LANDSCAPE PLAN
SDP4
SHEET 4 OF 16
ALC PROJECT #19-020

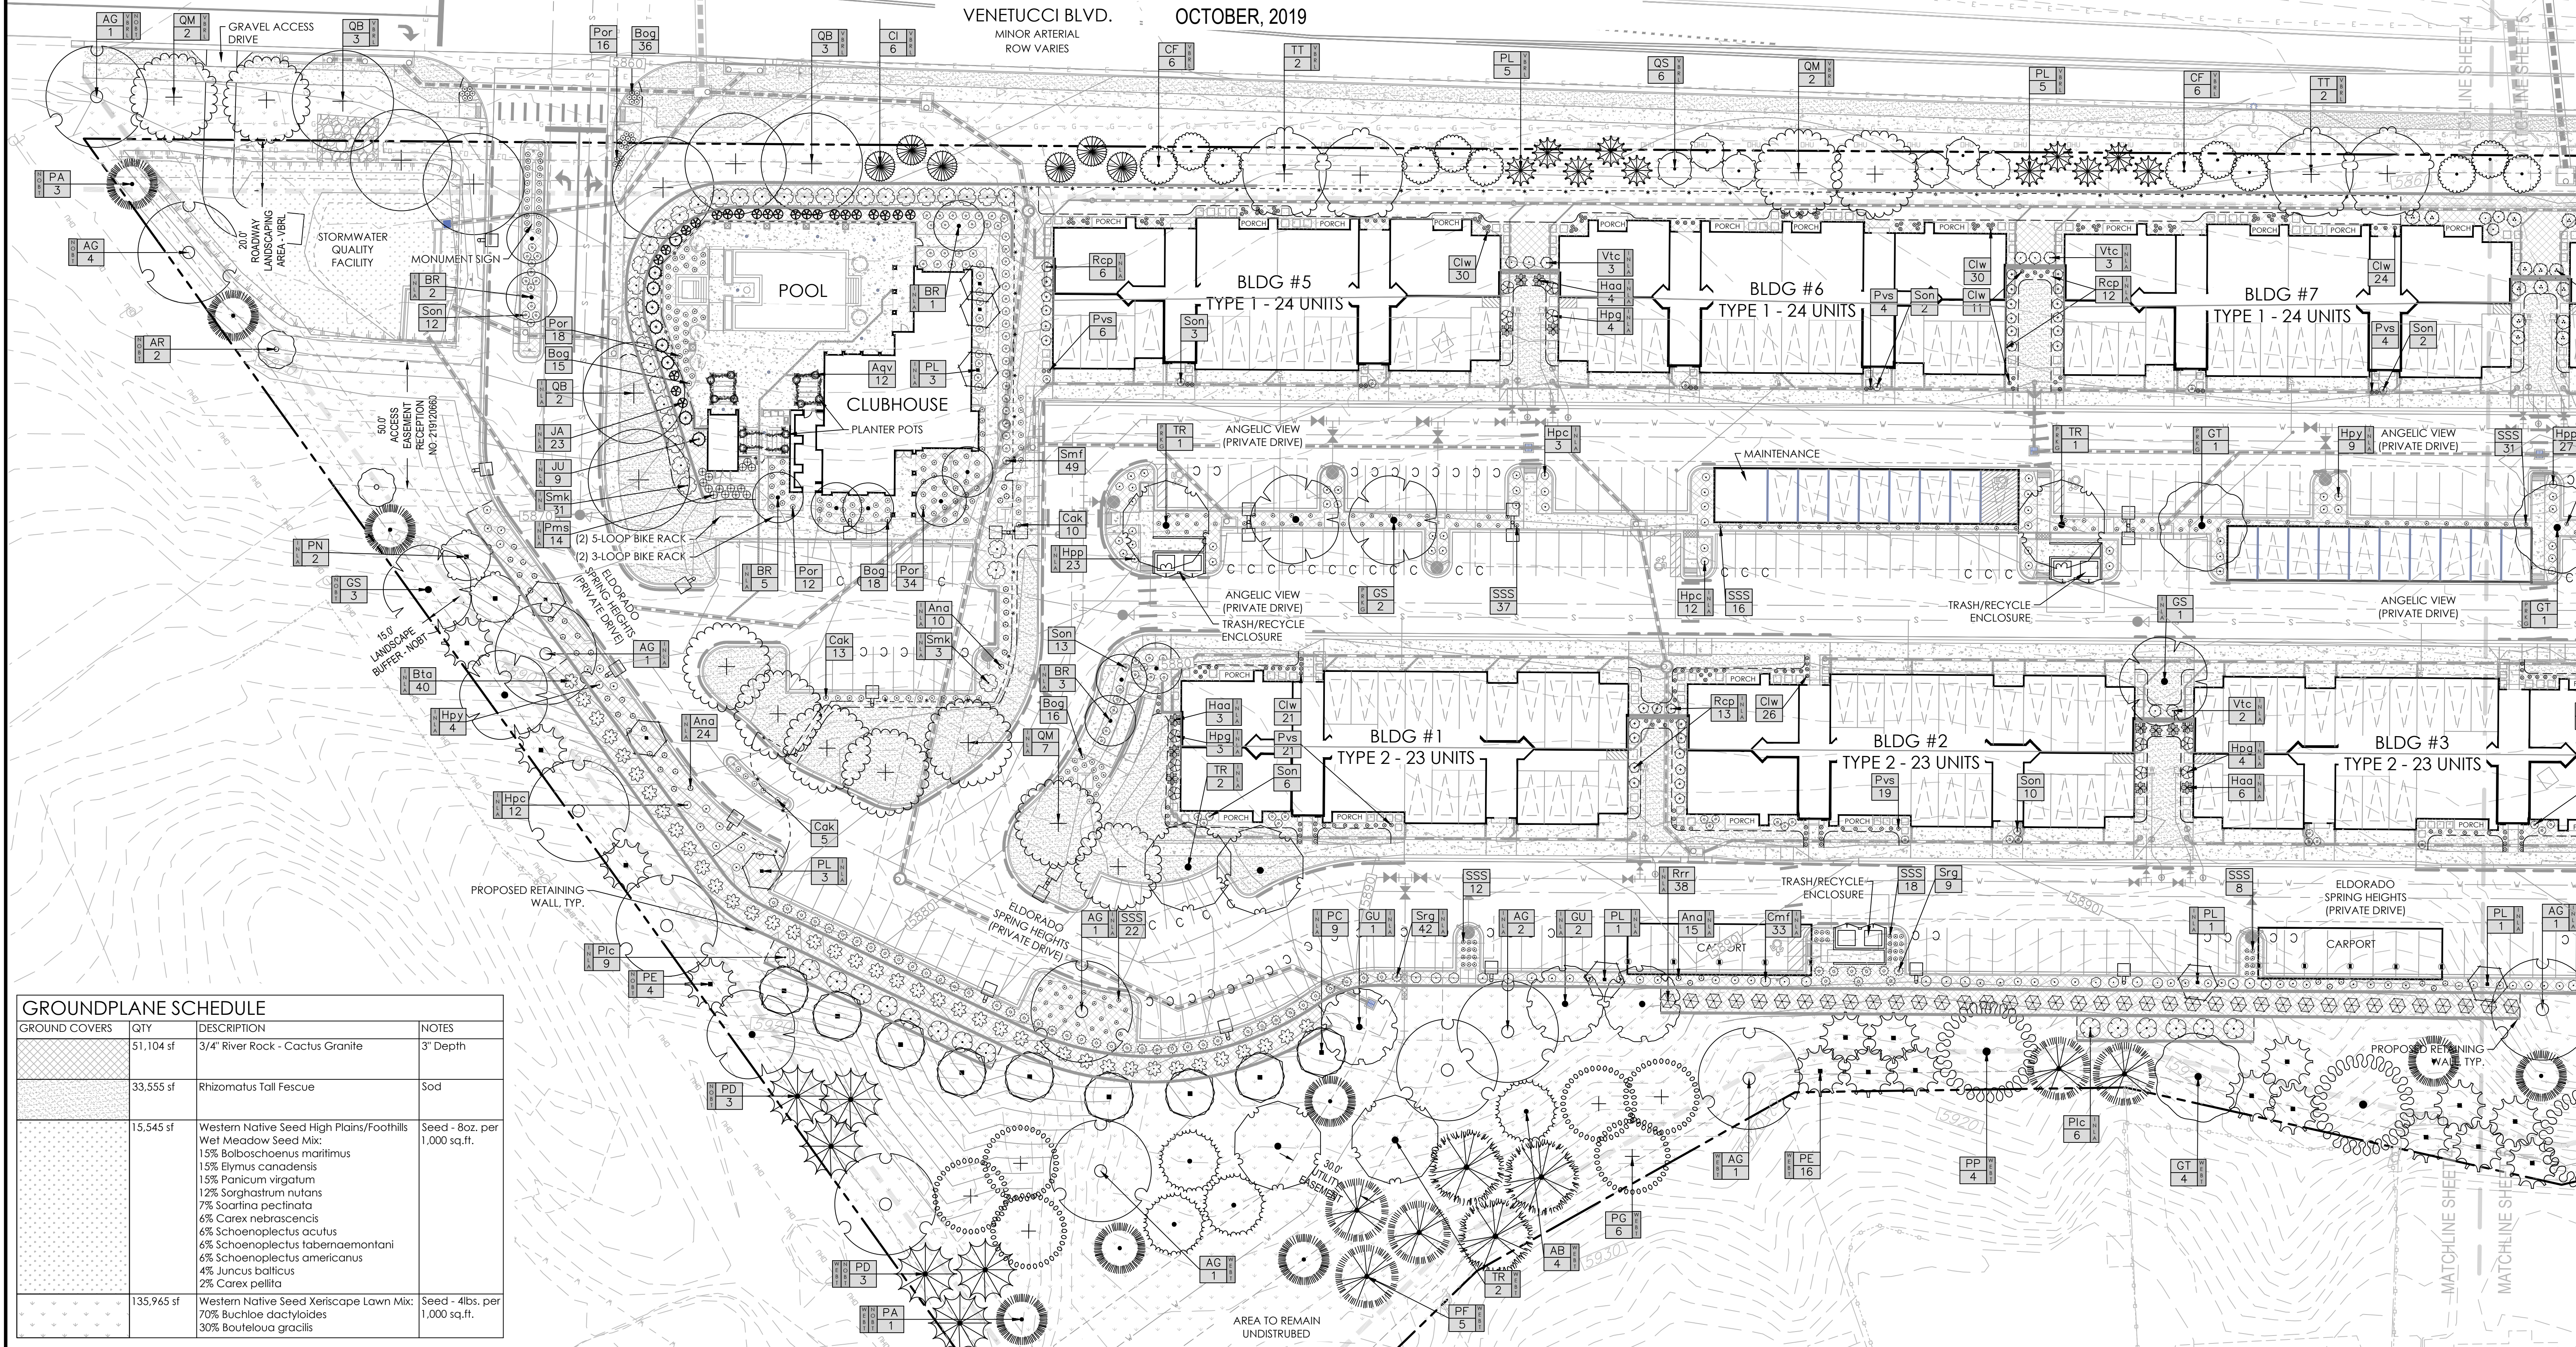
See notes on LOI and Landscaping Plan, what will caliber and maturity be at time of planting?

Response: Please reference the submitted buffer section, which is a more accurate representation of the grade change and landscape buffer location.

The section shows that there is a significant amount of grade change between the existing residences to the west and the proposed apartment site. The vertical elevation difference between the finished floor of the existing houses and the finished floor of the nearest apartment building is approximately 50-feet. Additionally, the closest house measures approximately 200-feet horizontal distance from the nearest apartment building.

A 6' fence is not necessary to create a buffer between the properties, as the grade difference, proposed retaining walls and dense landscaping provide a visual barrier between the properties. Furthermore, many of the existing homes have 6' cedar fences along their rear property lines as well as mature vegetation in backyards and along portions of the slope that are not to be disturbed. The combination of the existing fencing and vegetation with the proposed landscaping will create an appropriate buffer.

The proposed buffer includes a variety of evergreen species to be planted at minimum 6-foot height. Each of the buffers has at least 50 percent evergreen species, while the County requirement is 33 percent. The west side has 75 percent evergreen species, which will create a visual barrier as early as initial planting and will increase in density and fullness as the trees mature. On average, evergreens grow between 6 and 12 inches per year.
